From: Joe Russell-Wells
Sent: 13 May 2014 17:19
To: Neil Crowther
Subject: Land south of Littlehampton Academy - LU/51/14

Joe Russell-Wells | Environmental Services and Emergency Planning Manager, Greenspace and Emergency Planning, Arun District

DESIGN PROPOSALS - LAYOUT

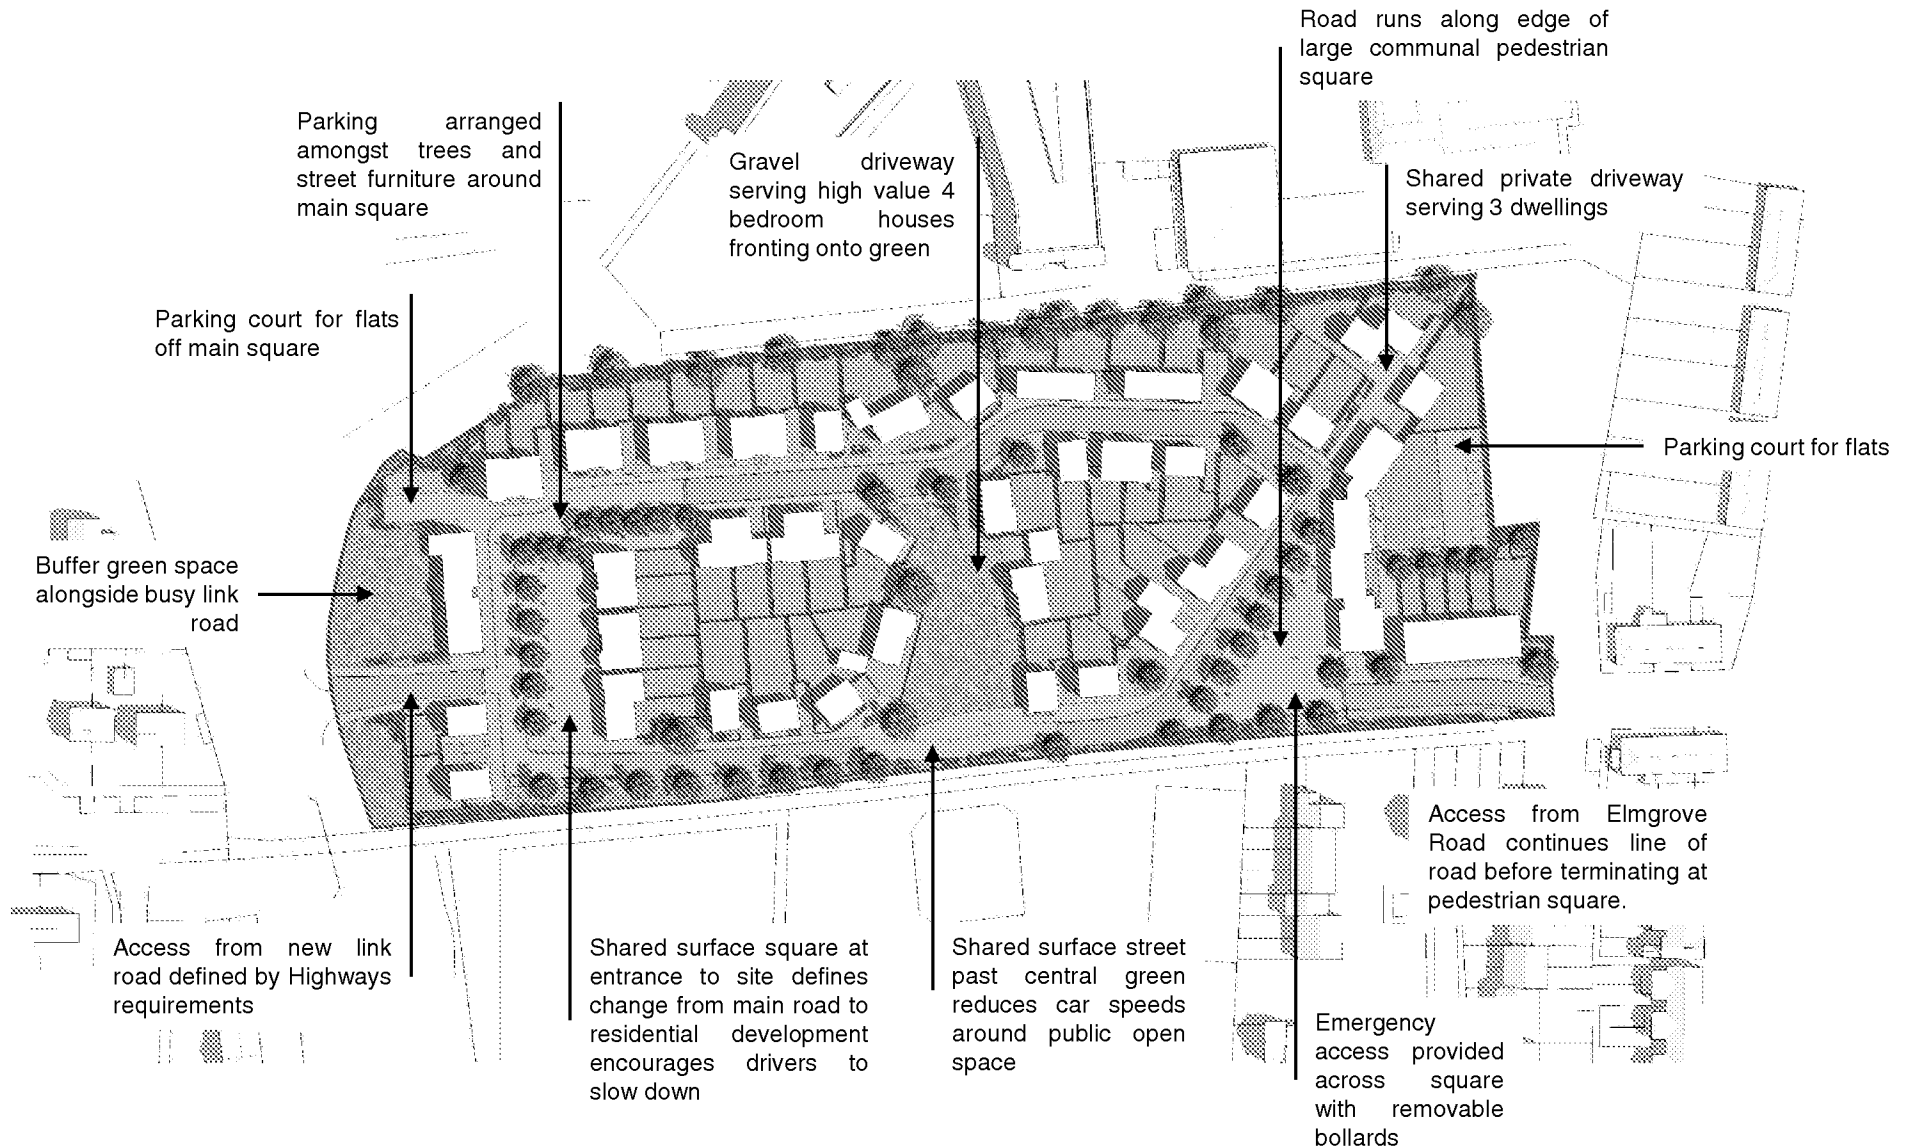
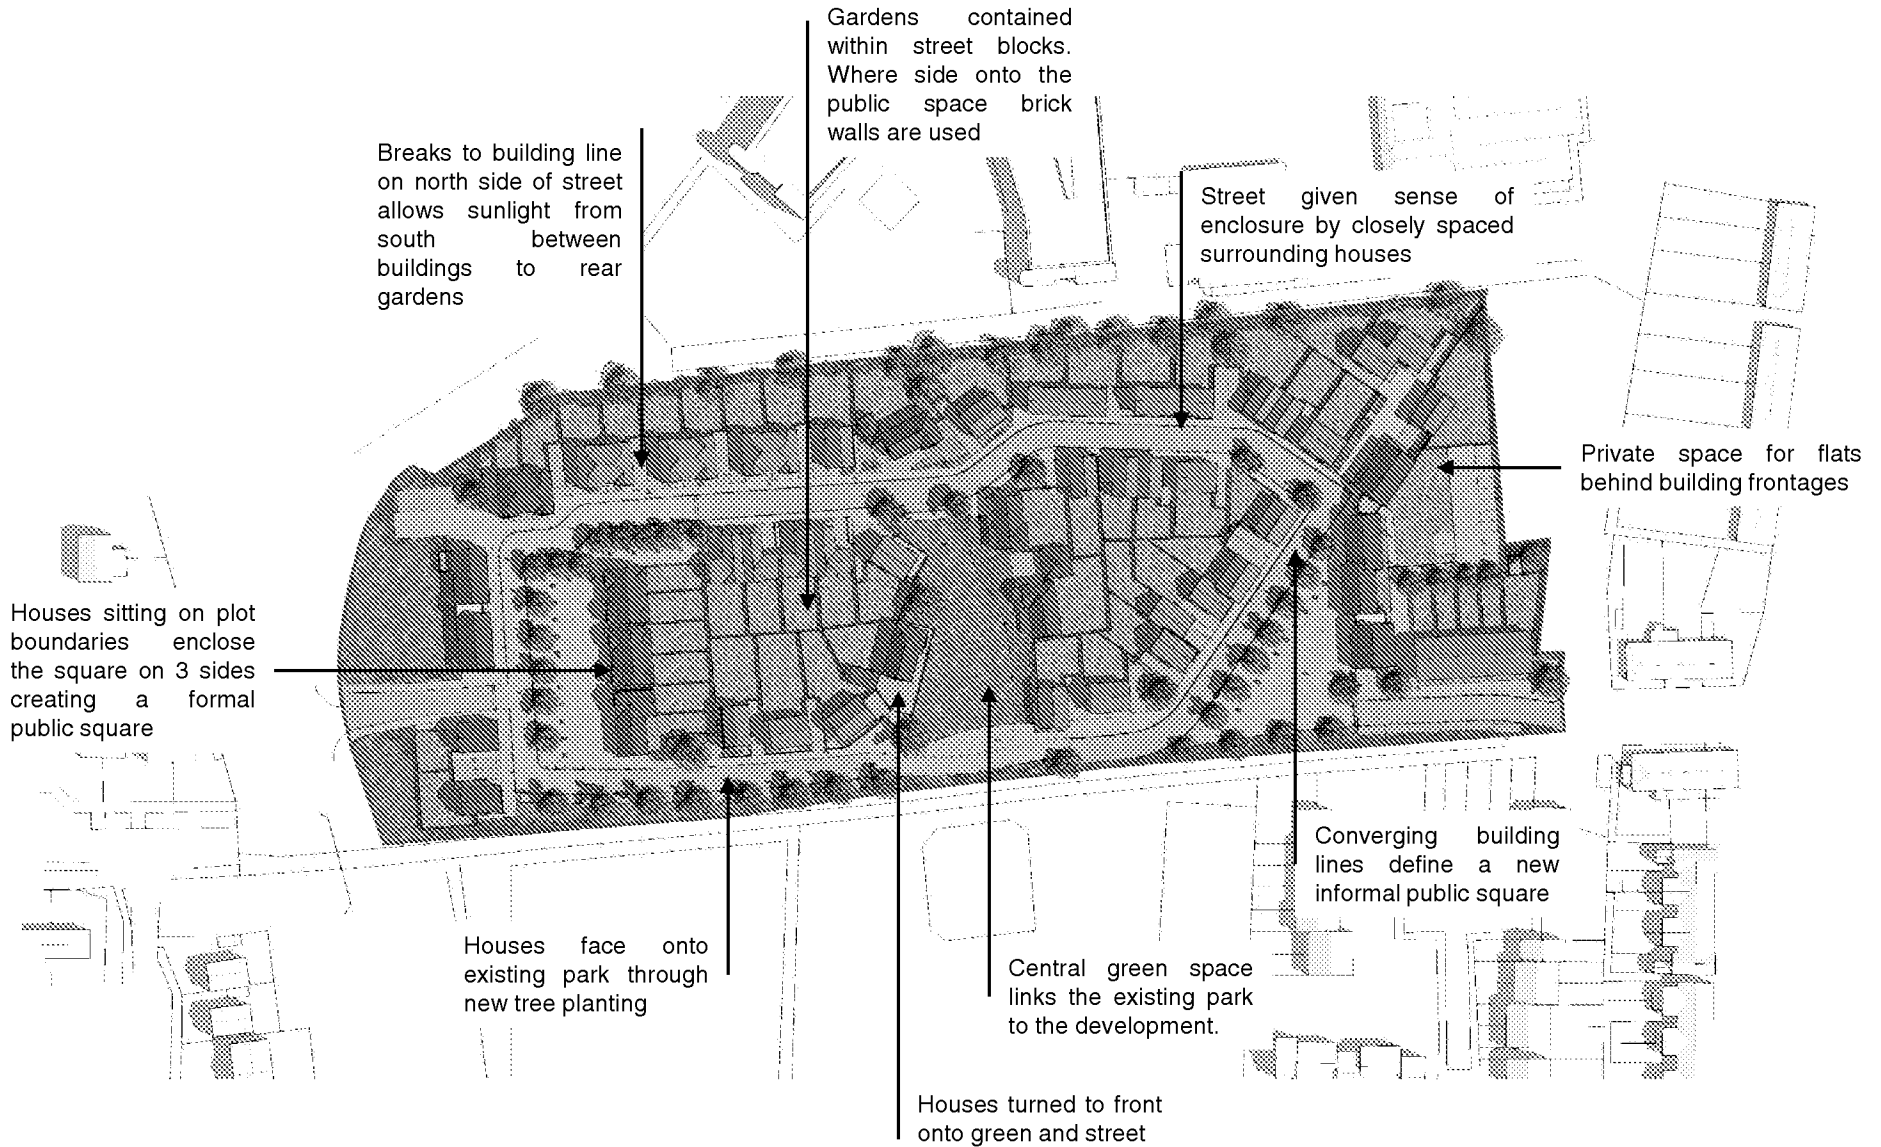
A development of this scale with the provision of 56 houses and 12 flats should be providing for an area of public open space of 0.3 ha in accordance with the Council's SPG. It is unclear as to the area of POS that would be delivered through these development proposals, until the amount of open space clearly identified on a plan is provided, it is guesswork to determine the open space provision, however on the basis of the proposed layout plan the it appears inadequate. The SUDS area adjacent to the new link road would be questionable as open space together with the paved squares. Together they provide a poor layout for the development in terms of open space provision.

There is neighbouring POS to the south of the development site it may therefore be appropriate for an off-site sum to be provided to enhance the existing provision together with good access links from the new development to the open space area. However until the proposed area of POS is clarified no further comment can be made.

In addition to the open space requirement there is the need for on-site provision of play area LEAP. Due to the close proximity of the nearby POS area it may be appropriate to have an off-site sum for improving the existing nearby play facilities – a figure of £68,000 the equivalent of £1,000 per residential unit would be appropriate.
